From: Fiona Fitzgerald <Fiona.Fitzgerald@arun.gov.uk>
Sent: 03 November 2020 09:50
To: Planning.Responses <Planning.Responses@arun.gov.uk>
Subject: FW: BE/92/20/DOC

From: Fiona Fitzgerald <Fiona.Fitzgerald@arun.gov.uk>
Sent: 21 October 2020 11:56
To: Planning.Responses <Planning.Responses@arun.gov.uk>
Cc: Maria Tomalova <Maria.Tomalova@arun.gov.uk>
Subject: BE/92/20/DOC

Environmental Health does not consider that the Drawing No. 871/PL02 Rev A constitutes a scheme for the control of dust from the site. It does not detail the sources of the dust, although it is assumed that the site access road is a source of dust. Therefore if there are further sources of dust other than the site access area, these have not been considered or mitigated.

DWG NO	871/PL02	REV. A
---------------	----------	---------------

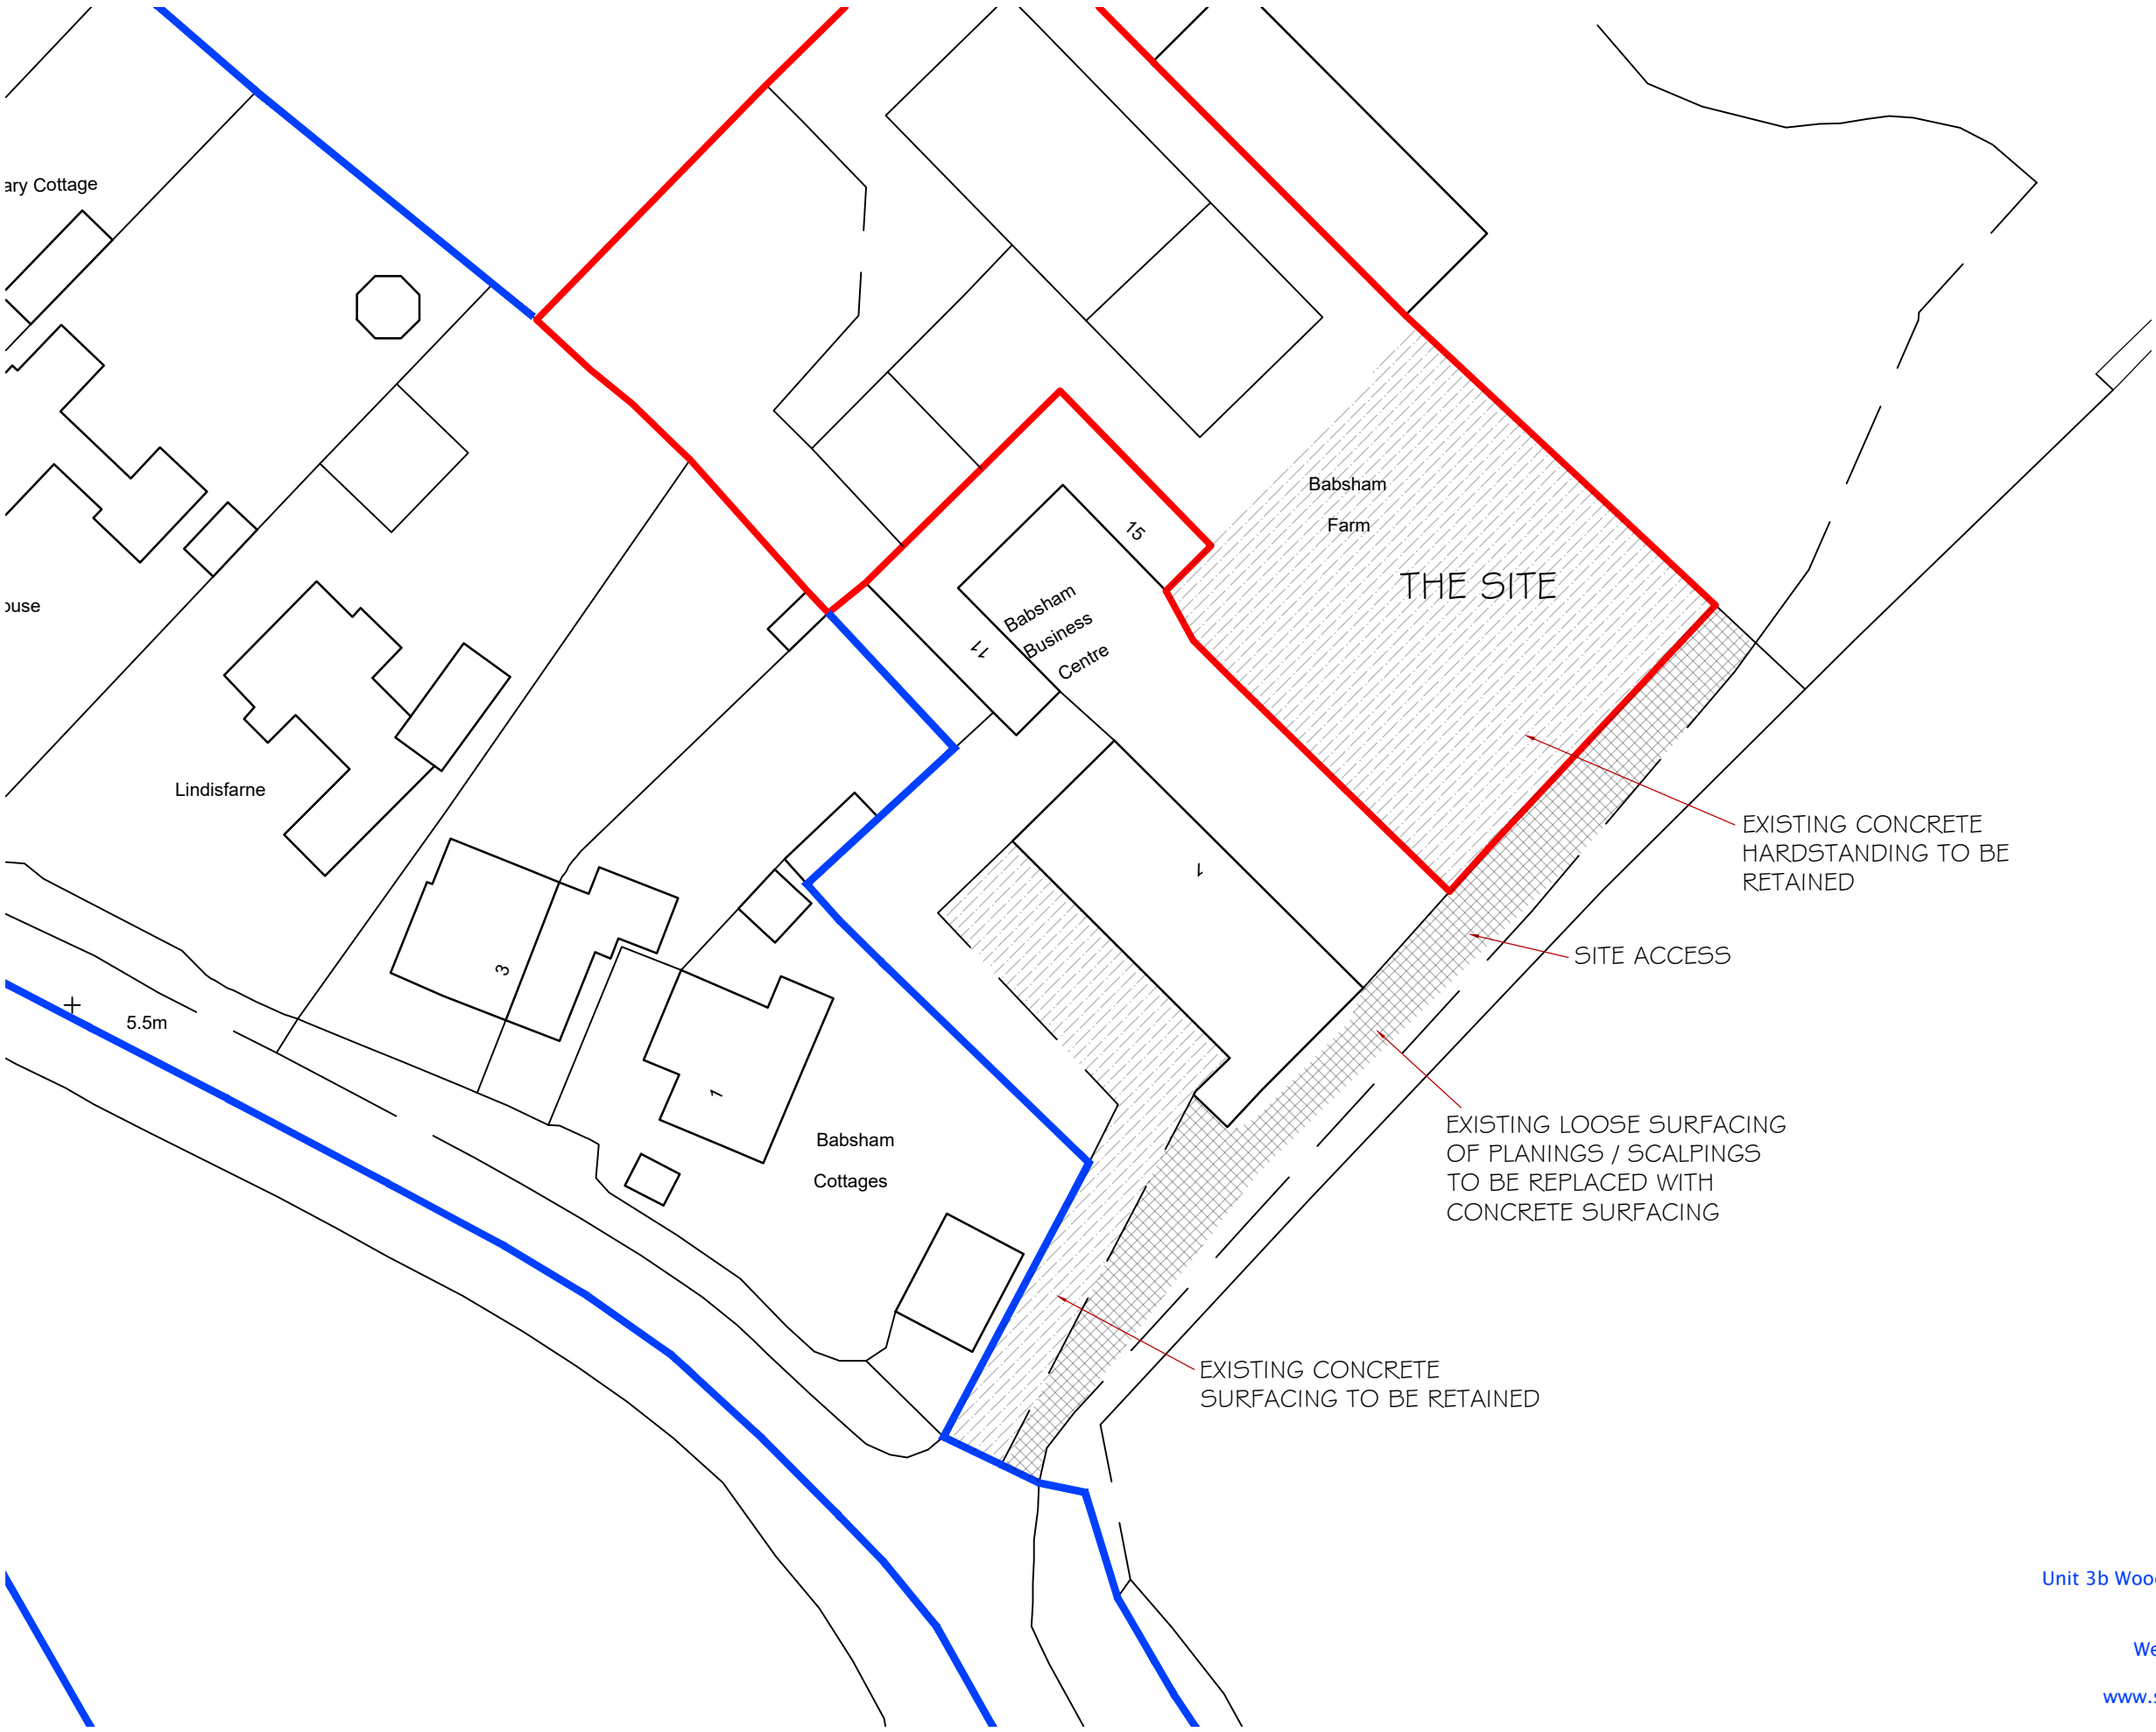
Please could the applicant confirm whether or not the site access road is the only source of dust expected, and if not, what the other sources are and how they will be controlled? Please could the applicant also advise whether muddy vehicles are likely to enter or exit the site and whether or not this is a source of dust that may need to be controlled by a wheelwasher or similar?

I can confirm that the only source of dust on the site is the existing un-made access drive. The resurfacing of this access drive will remove this source of dust. It is not envisaged that vehicles with particularly muddy wheels would be likely to enter or exit the site.
